**veWEST SUSSEX COUNTY COUNCIL
STRATEGIC PLANNING CONSULTATION**

SUBJECT: A/138/13 - Outline application for the erection of detached dwelling house - this application affects the setting of a Listed Building.

Land at the rear of The Old House, High Street, Angmering, West Sussex, BN16 4AG

BLOCK PLAN
Scale 1:500

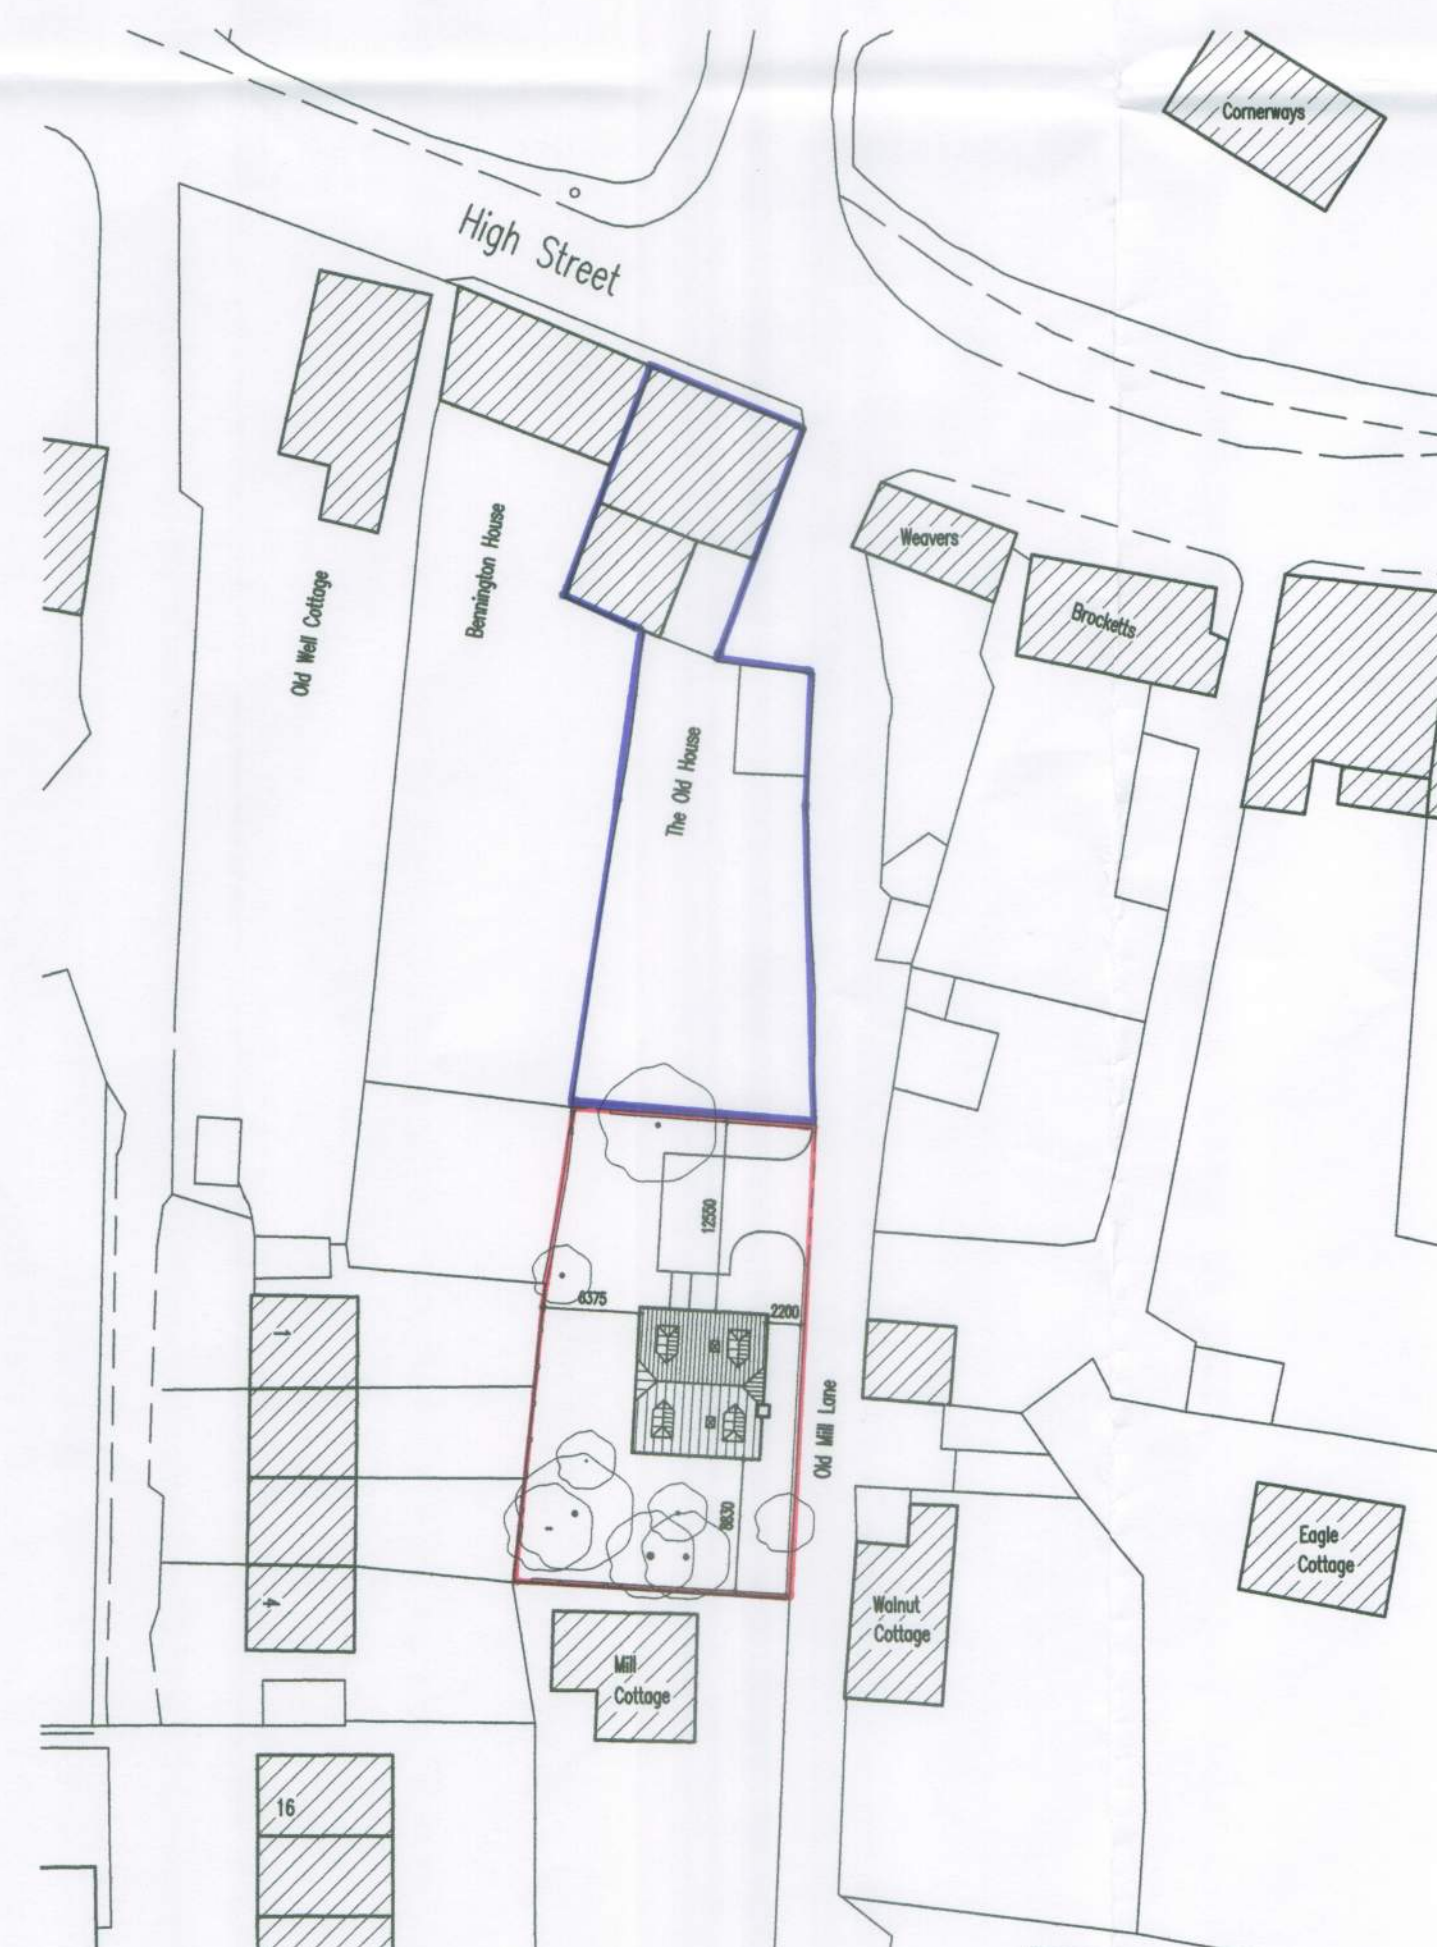
From inspection of the plans and information provided within this application, it is proposed to offer 2 off-street parking spaces within the site for use by the future occupiers of the dwelling. It would appear that a turn on site would not be achievable within the confines of the application site; however, vehicles reversing on to Old Mill Lane would not deem to be a significant concern due to it being a no through road with limited traffic movements occurring. Irrespective of this, a vehicle will either way be able to exit on to High Street in the forward gear, gaining the appropriate visibility.

The amount of 2 spaces would meet the demand for a dwelling of this size in this area. Cycle parking is also proposed of 2 spaces; this should be secure, covered and secured by condition to provide alternative travel options to the use of the car in accordance with current sustainable transport policies
